Town and Country Planning Act 1990 Refusal of Planning Permission

Reference: H16-0131-15 Received: 18th February 2015 Type: FULL

Description: Proposed dwelling
Location : River Bank Spalding

Scale 1:50 1:100	Drawing No. 1415-01
Date: MAY '14	Drawn: J.C.

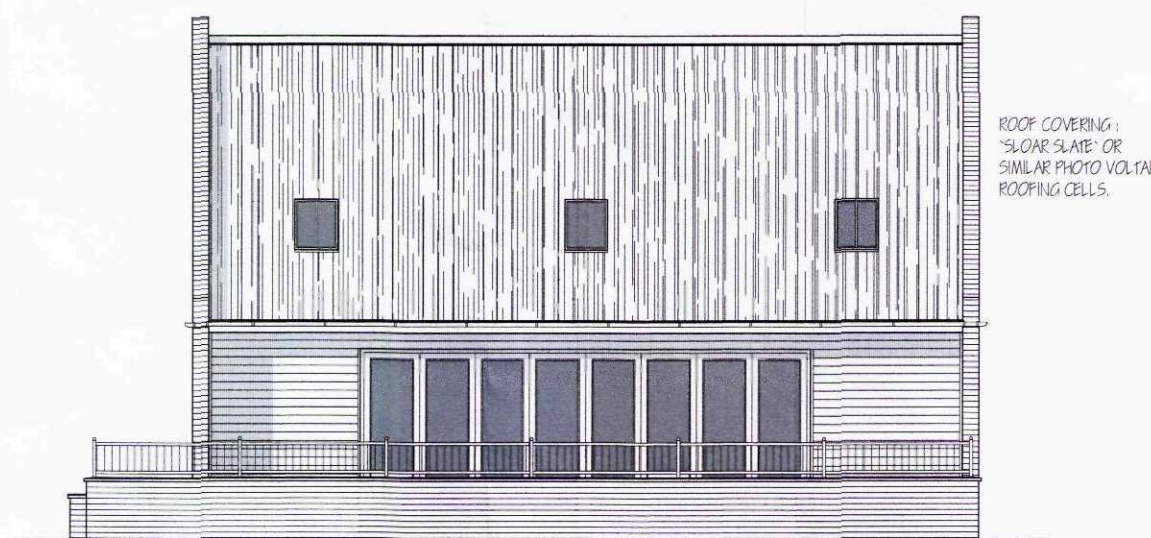
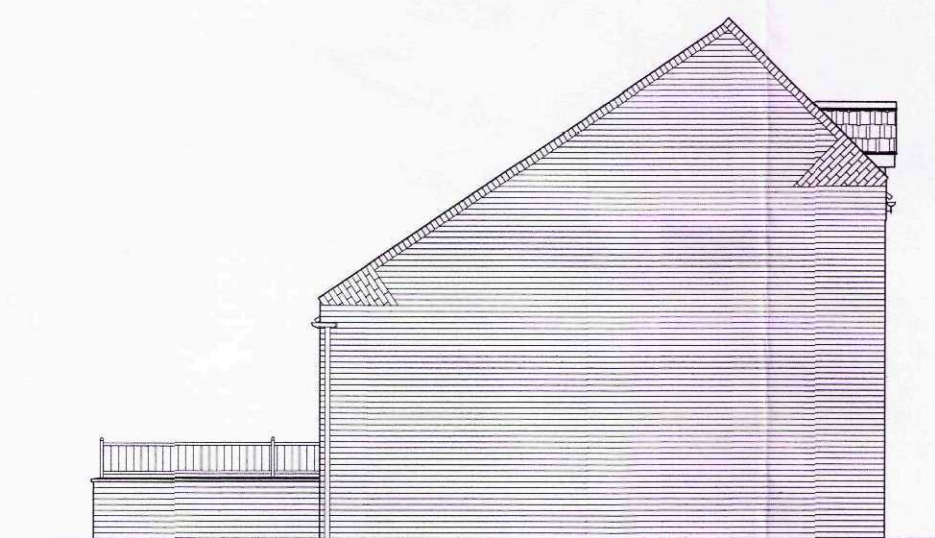
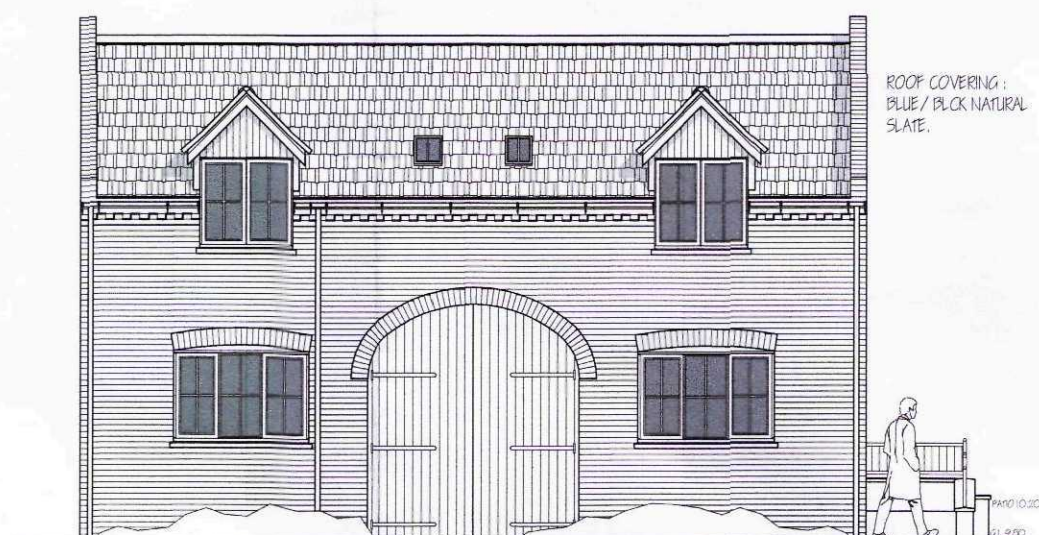
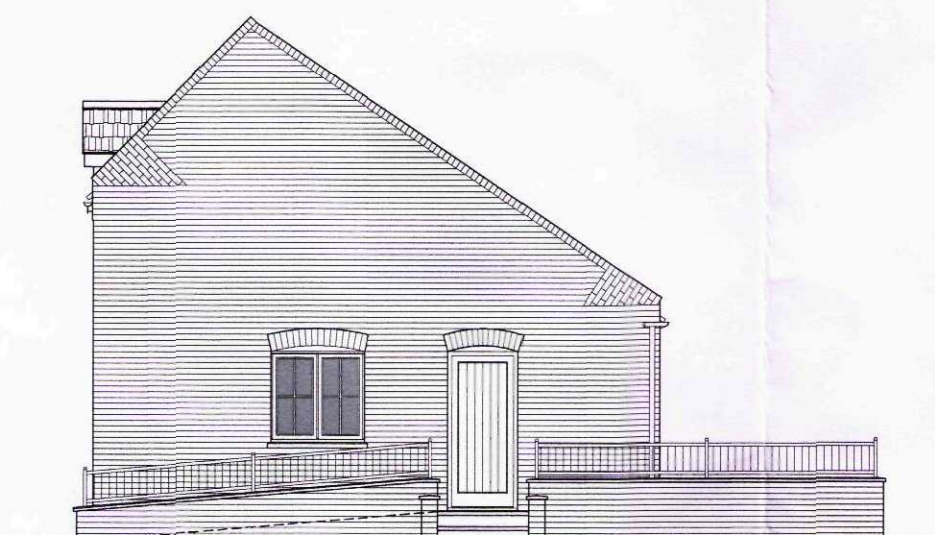
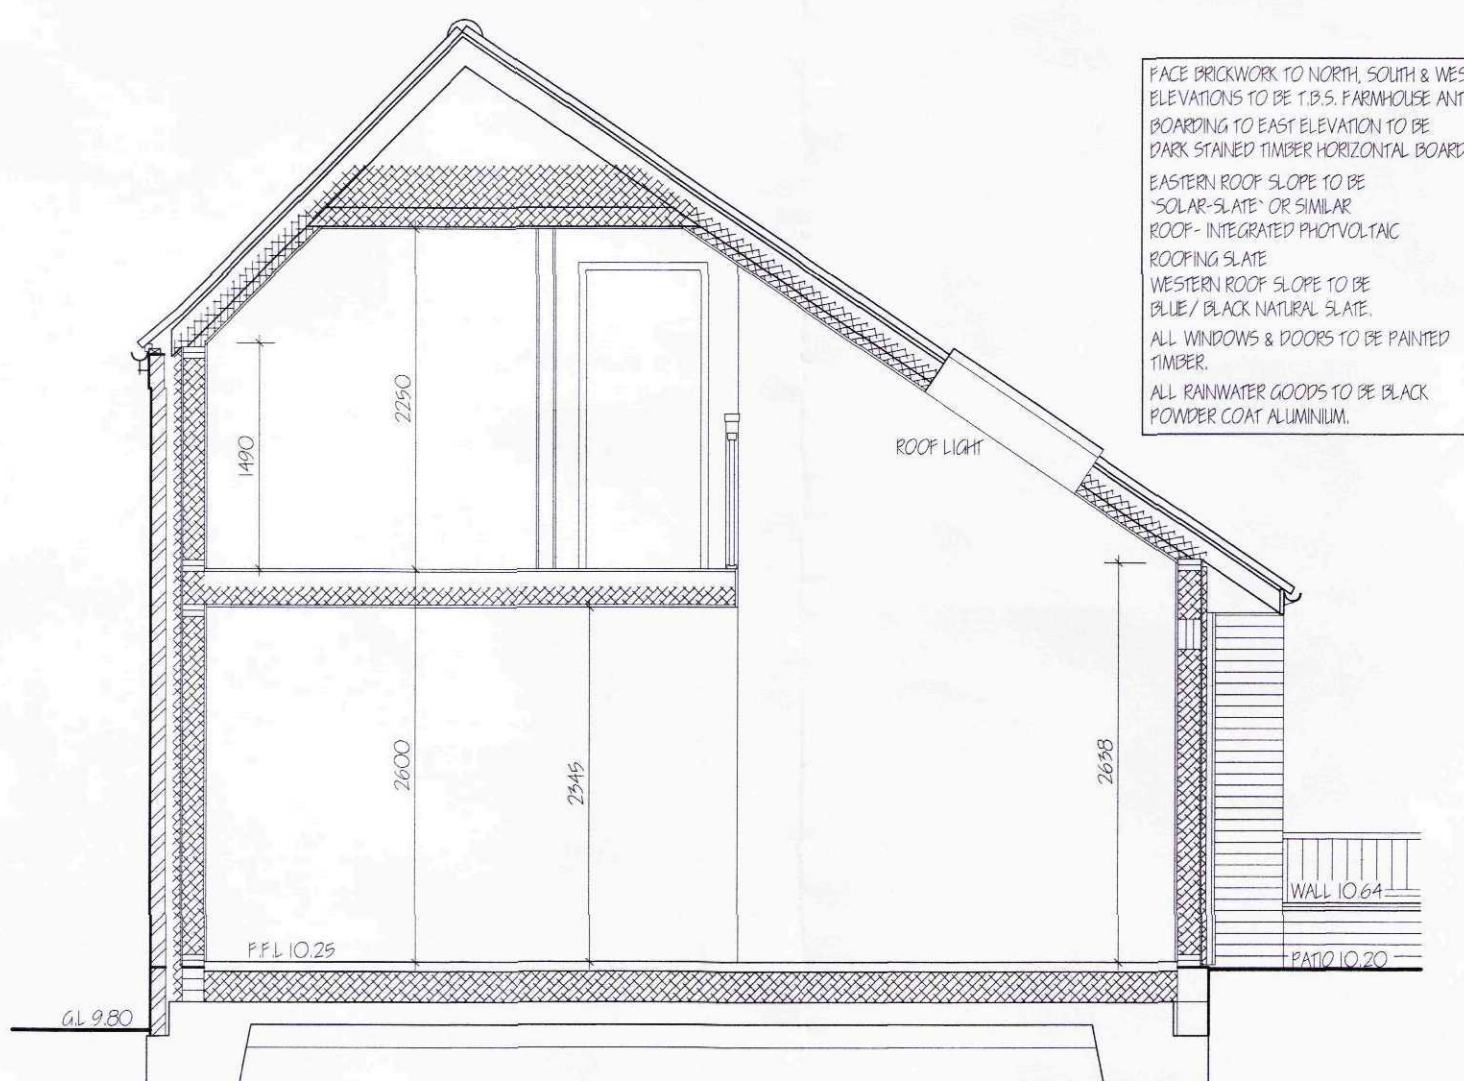
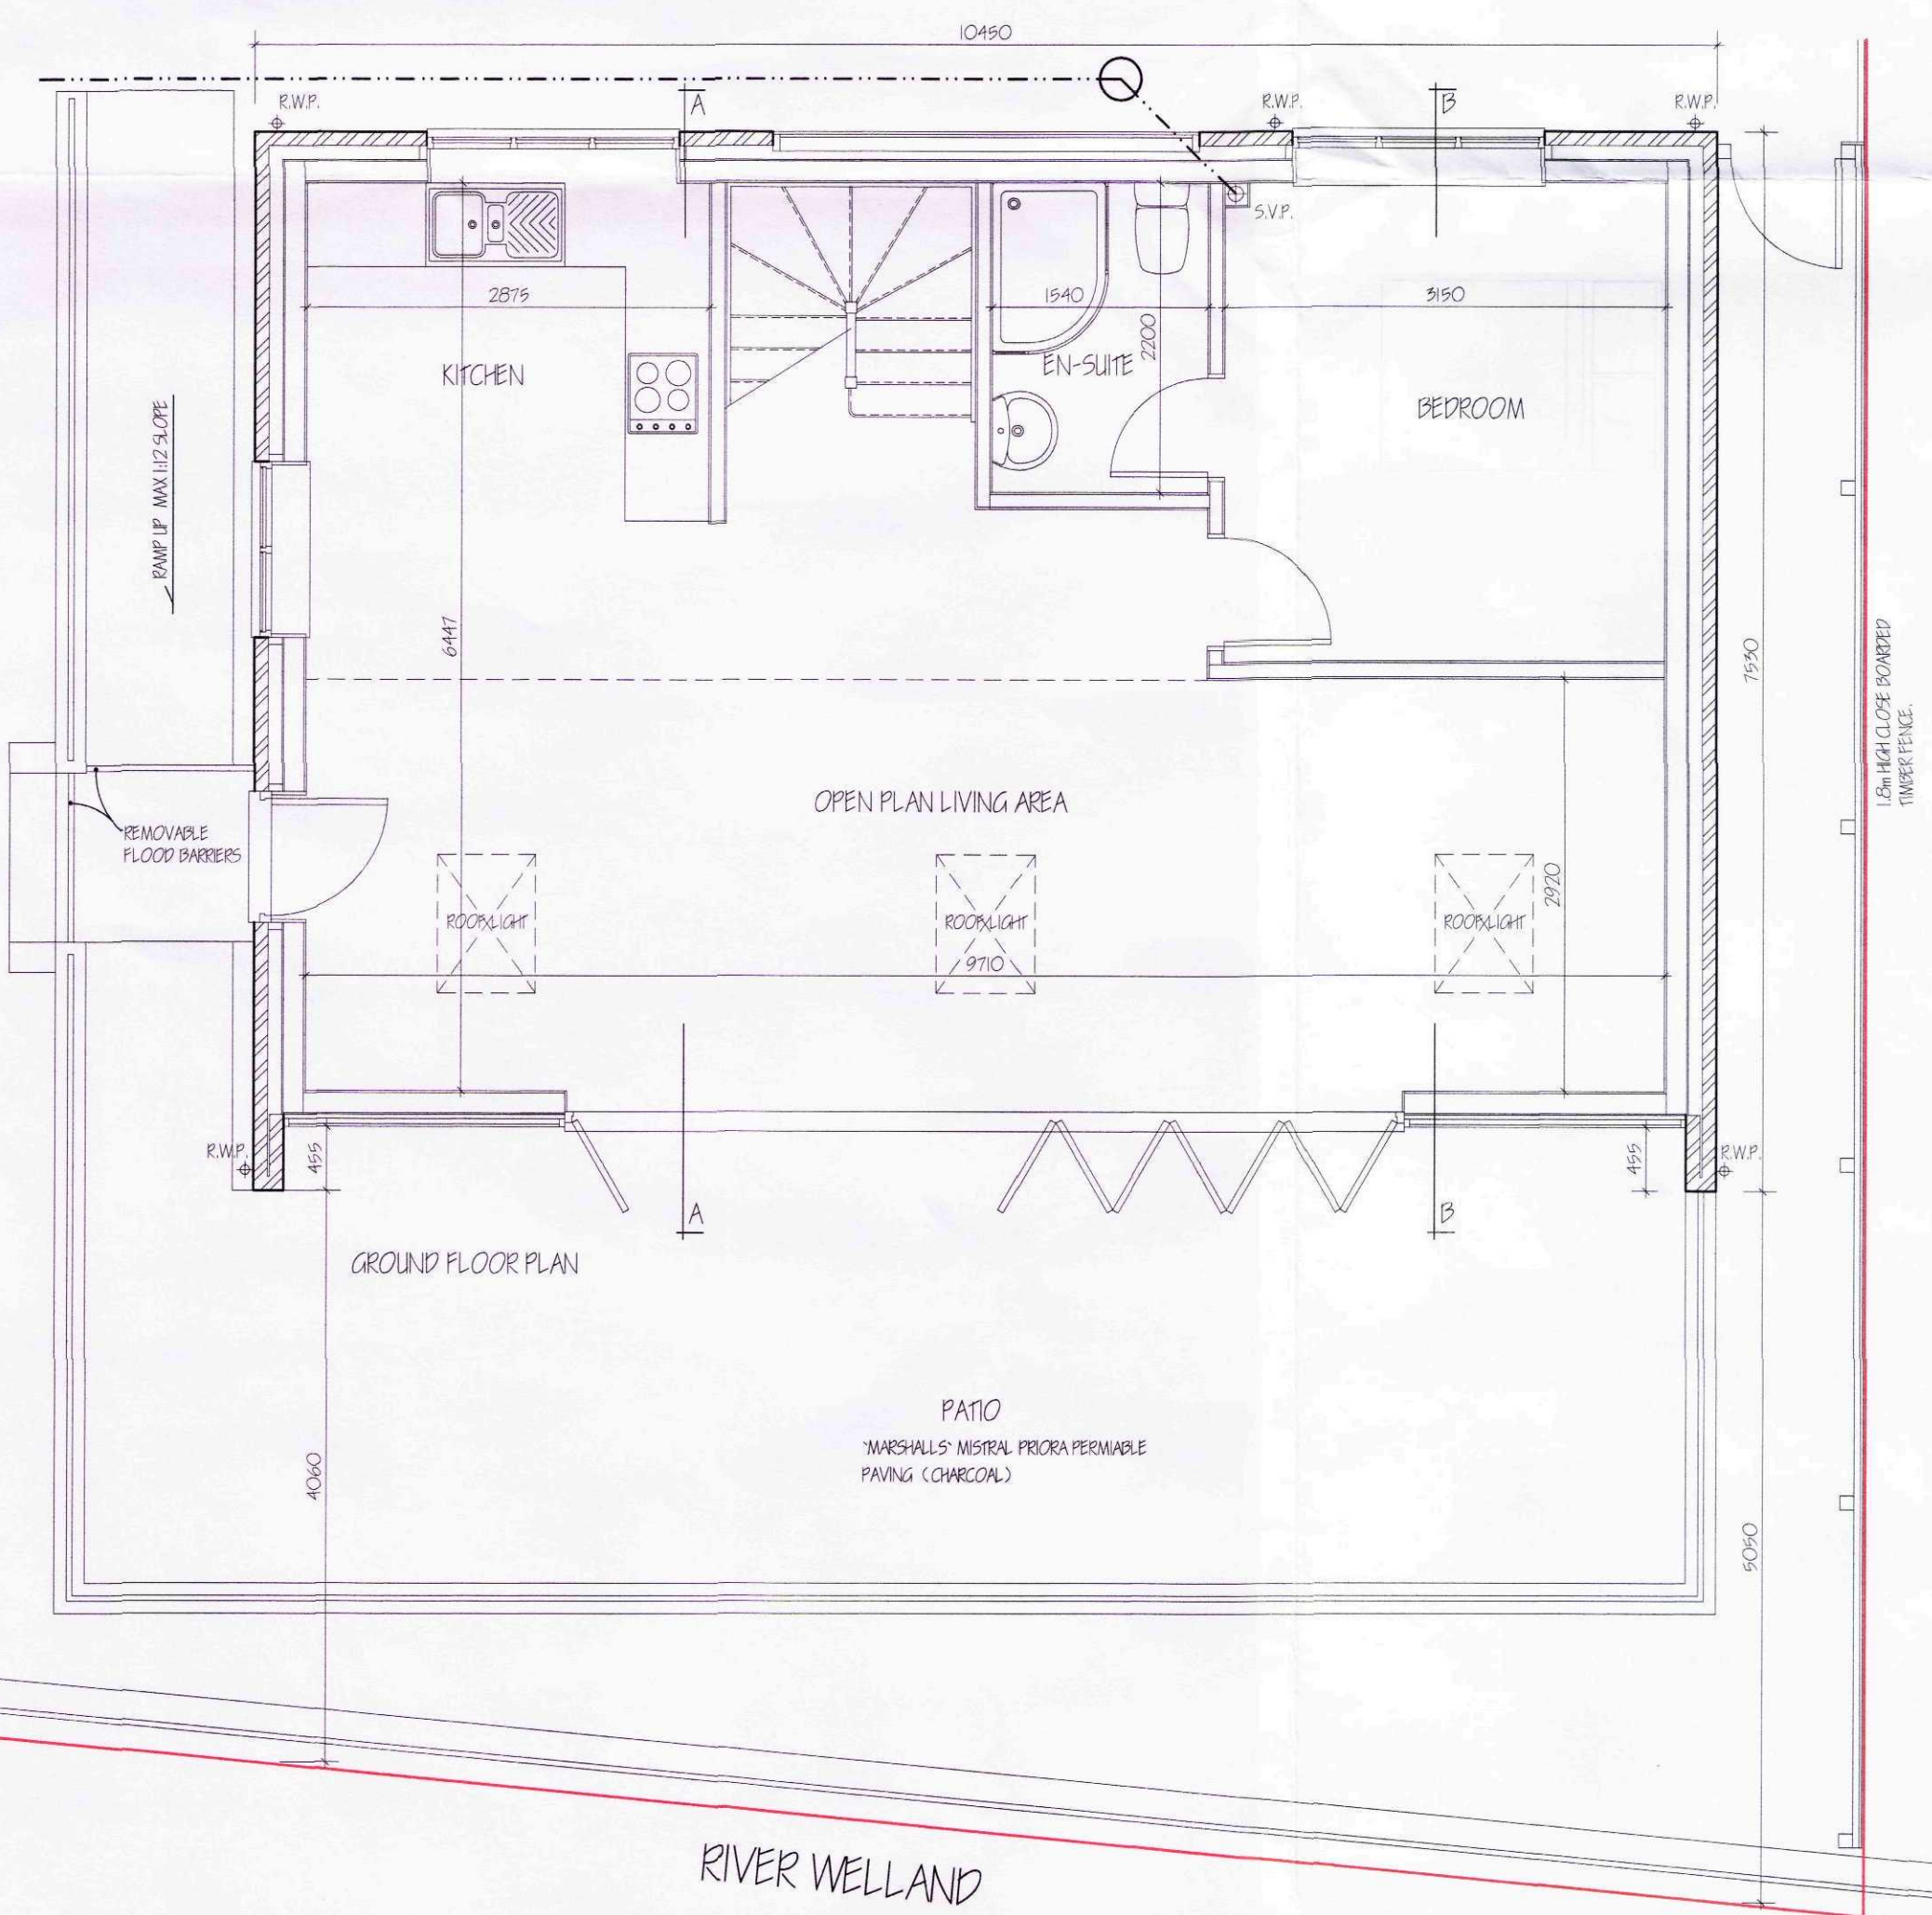
- 1 By virtue of its location and its two storey design, the proposed house would unacceptably threaten the privacy of habitable room windows within the nearby number 9 River Bank, some 8 to 9 metres distant. Furthermore, any active use of the proposed garden area including re-erection of the current "summer house" as indicated on the submitted Block Plan would have an unacceptable and un-neighbourly impact upon the character and appearance of the locality as a whole, notably including numbers 9, 10 and 11 River Bank. The proposed dwelling would therefore be contrary to the objectives of Policy SG14 of the South Holland Local Plan and Section 7 of the National Planning Policy Framework.
